# **Application by Highways England for an Order Granting Development Consent for A57 Link Roads**

## **The Examining Authority's third written questions and requests for information**

### **High Peak Borough Council's Response**

- LEGEND**
- MODELLED QUALIFYING FEATURES AND PUBLIC ACCESS
  - DEFRA PCM LINKS COINCIDING WITH ROADS MEETING THE DMRB LA105 TRAFFIC SCREENING CRITERIA
  - ROADS MEETING DMRB LA105 TRAFFIC SCREENING CRITERIA

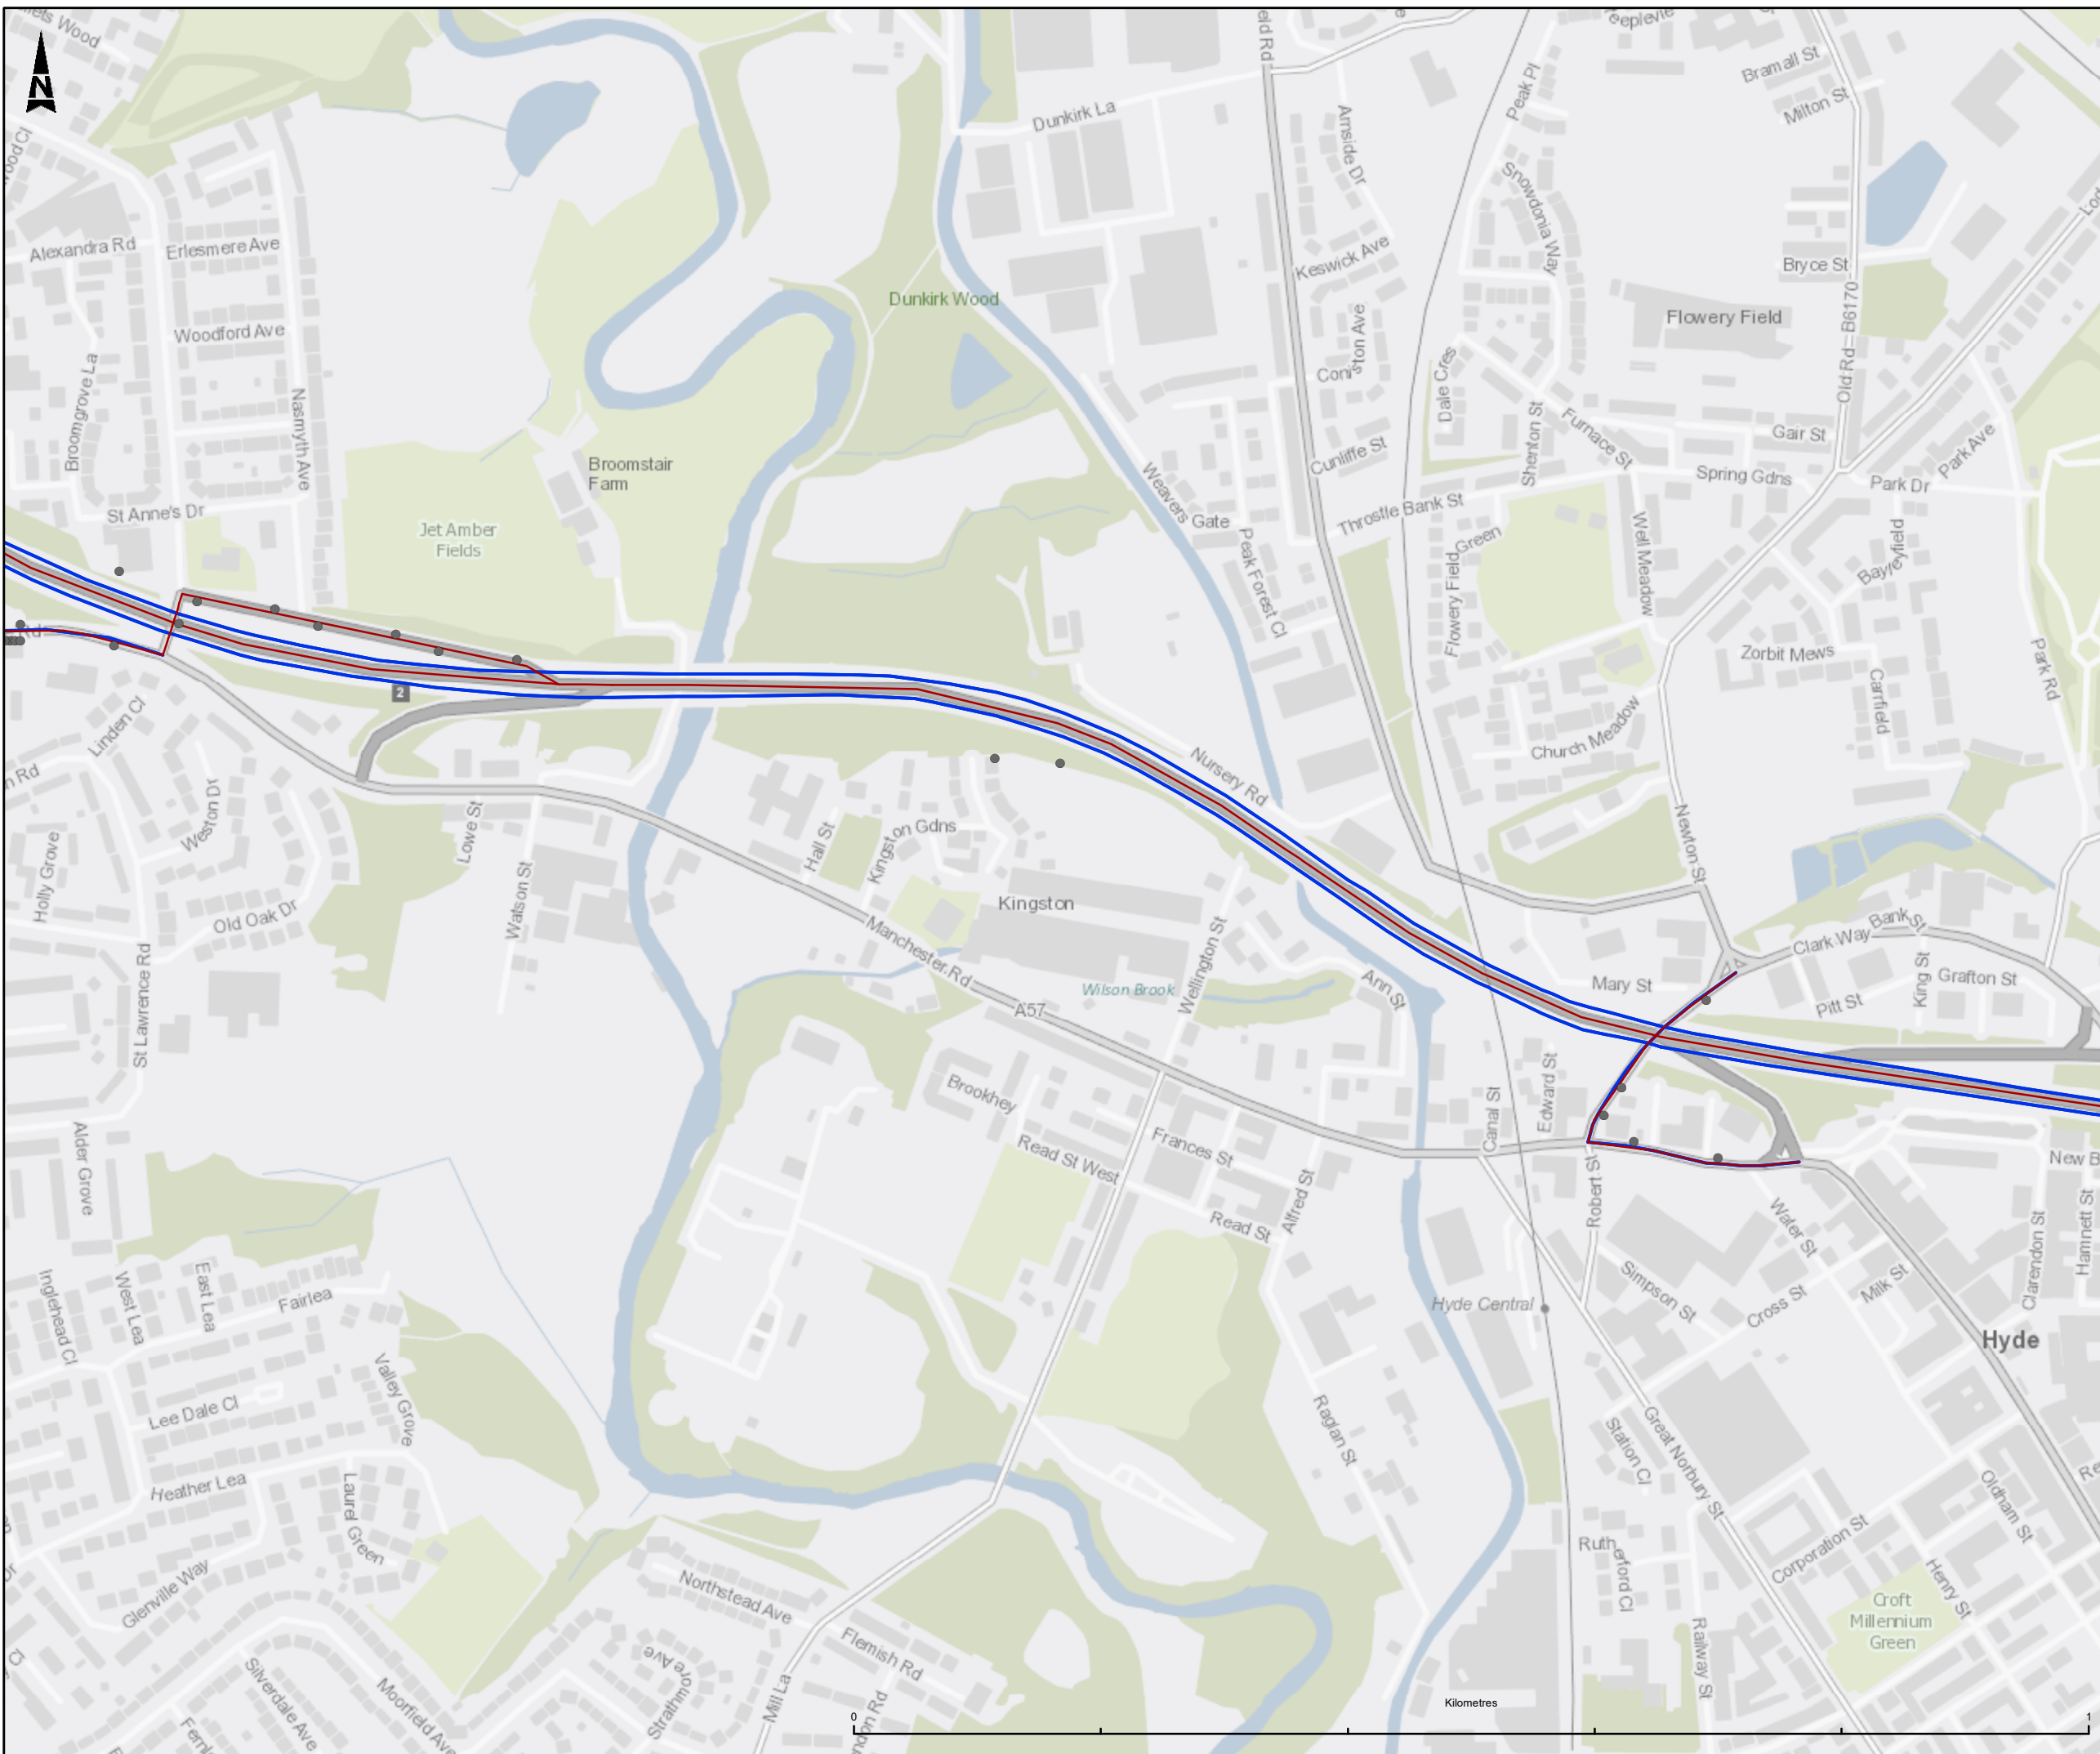
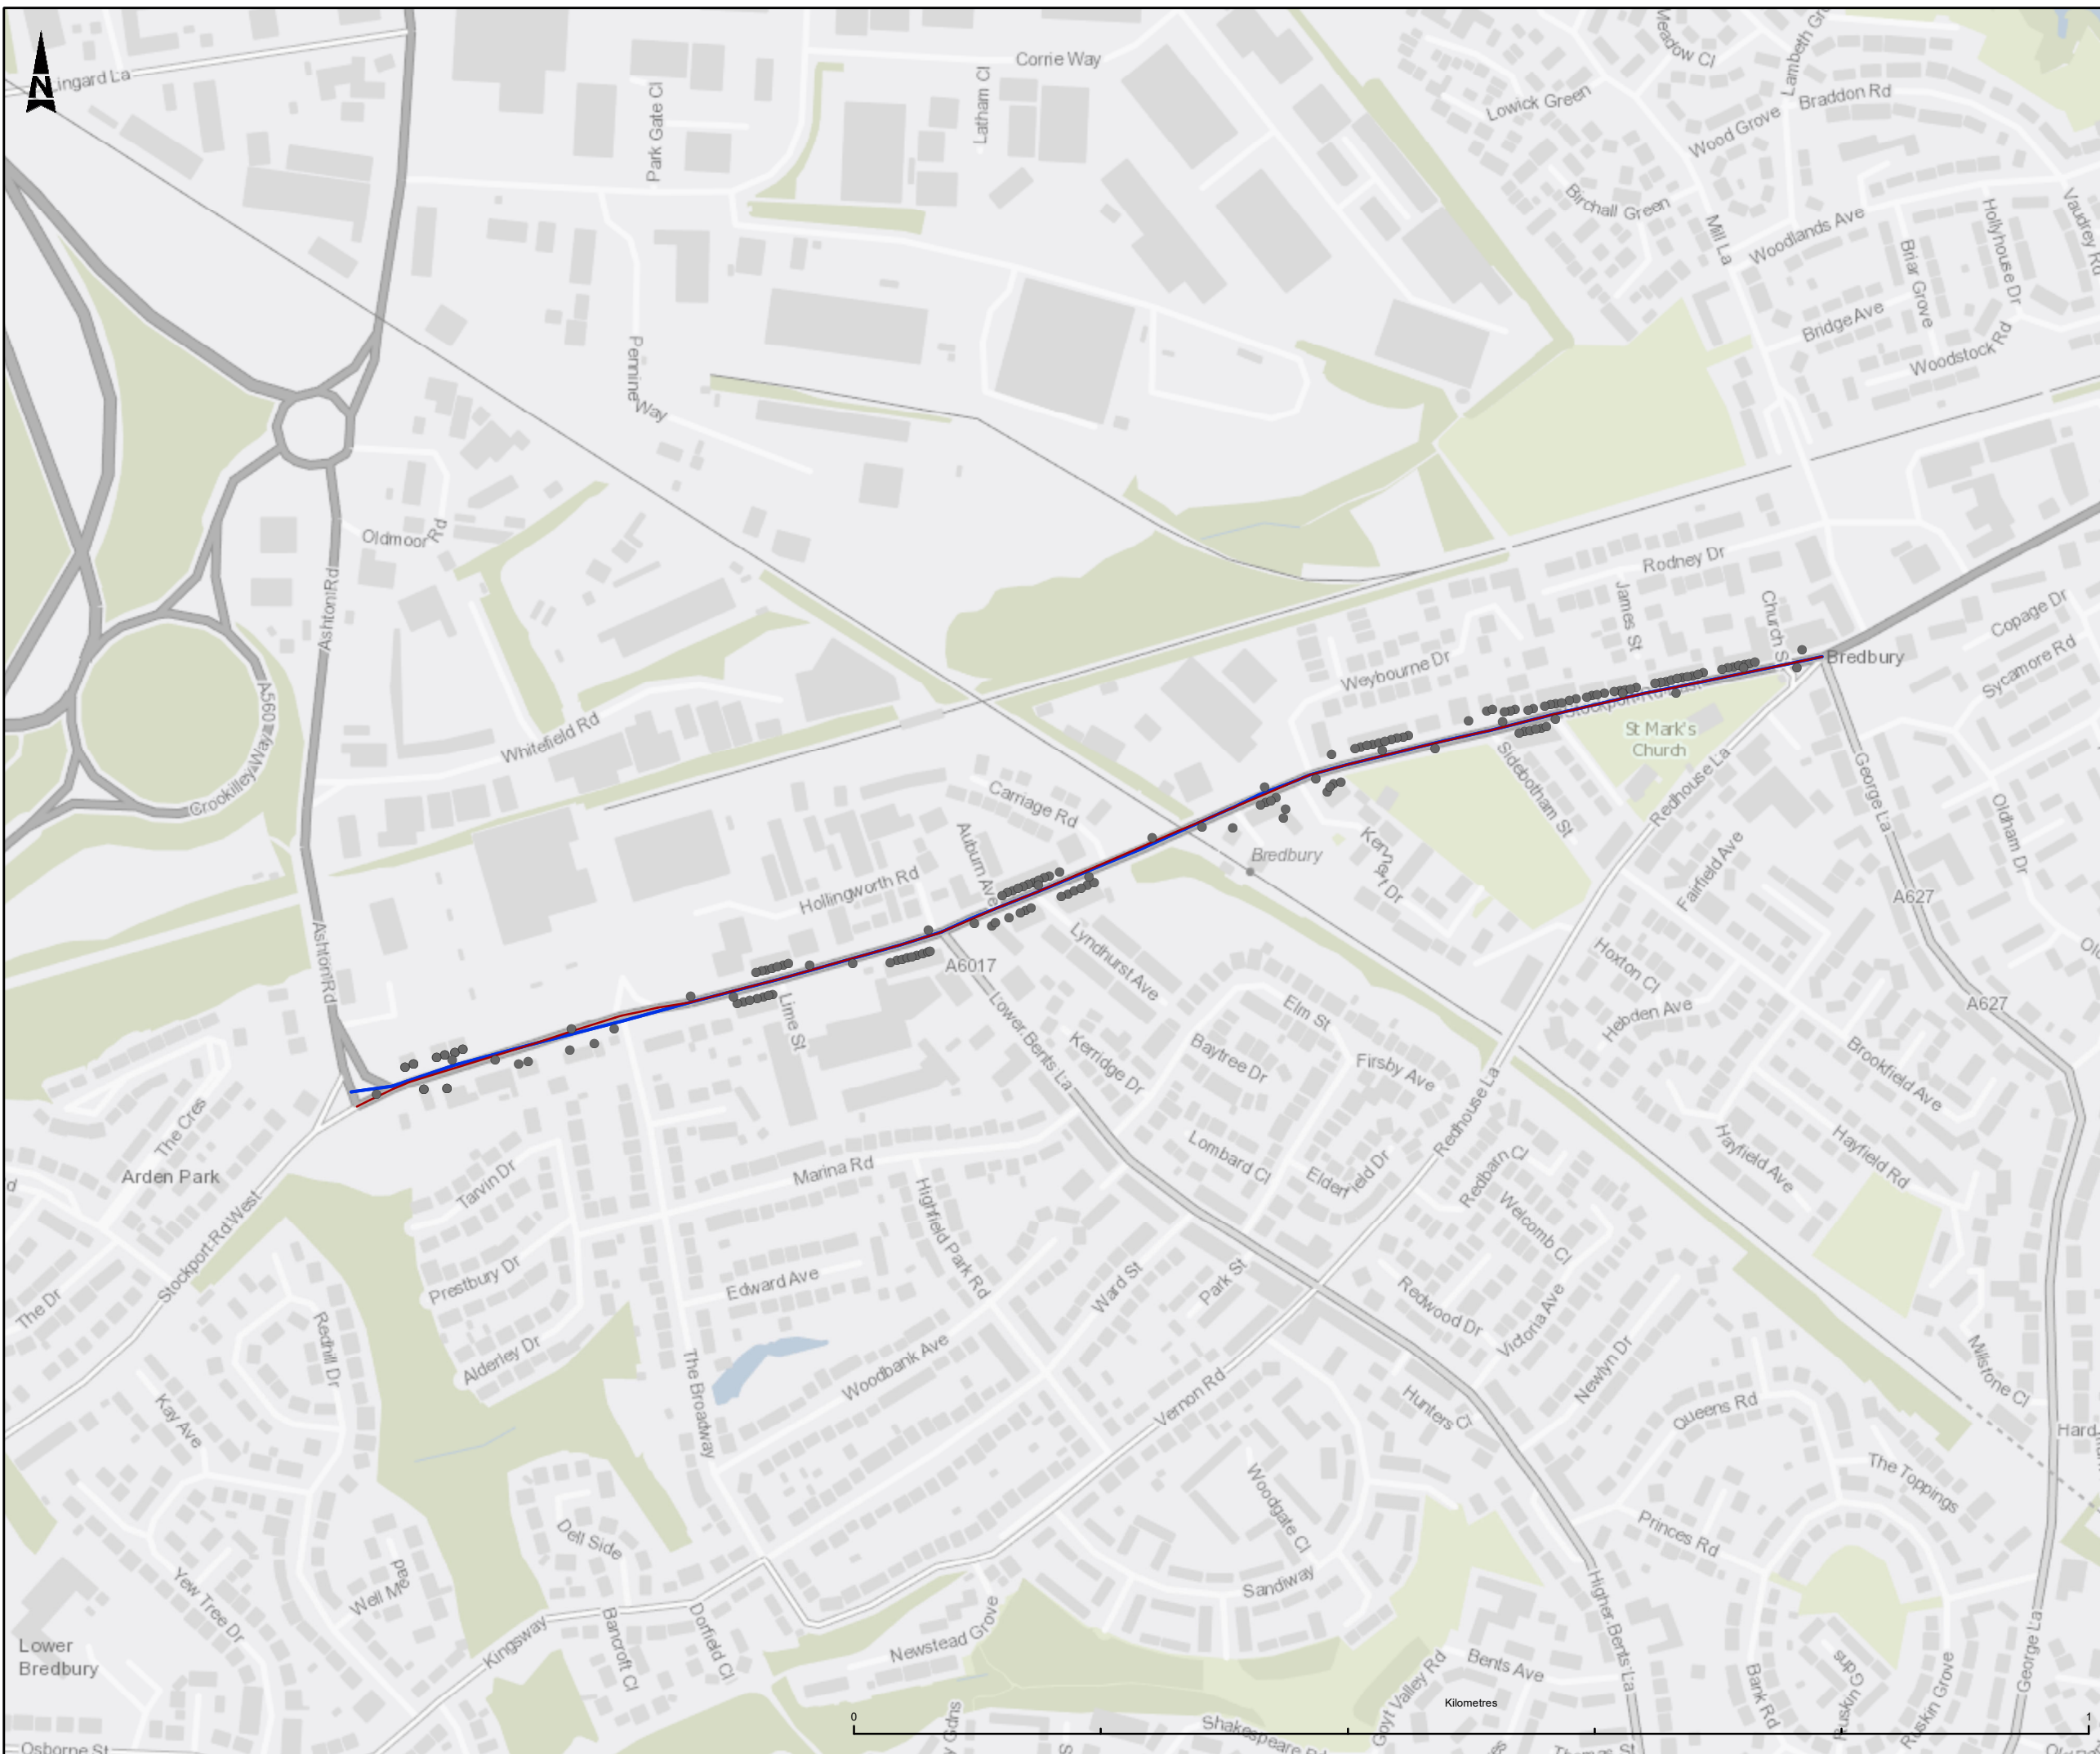
Identification of the receptors (figure 5.4) used in the compliance risk assessment (using LAQM “conservative” forecast”) indicated that “large” change at some of the receptors along Brookfield.

However, it also highlighted that some of these were human health receptors that had not been included as receptors in the (less conservative) primary human health AQ assessment (DMRB LA 105). Therefore, HPBC have requested that these receptors are also assessed in accordance with the DMRB LA 105 . Following further discussion and clarification (virtual meeting held 8th April 2022) it was agreed that a sensitivity test will be undertaken to identify the air quality impact at relevant qualifying feature receptors located adjacent to the A57 Brookfield under the DMRB LA 105 human health assessment methodology (to be submitted by National Highways at deadline 11 – ref. TR010034/EXAM/9.86)

Results from the updated air quality assessment updated DMRB LA 105 indicated a “Large increase” in NO<sub>2</sub> DS compared to DM in 2025, at locations along Wooley Bridge with 1 location exceeding the AQO (40ug/m<sup>3</sup>) as a result of the scheme.
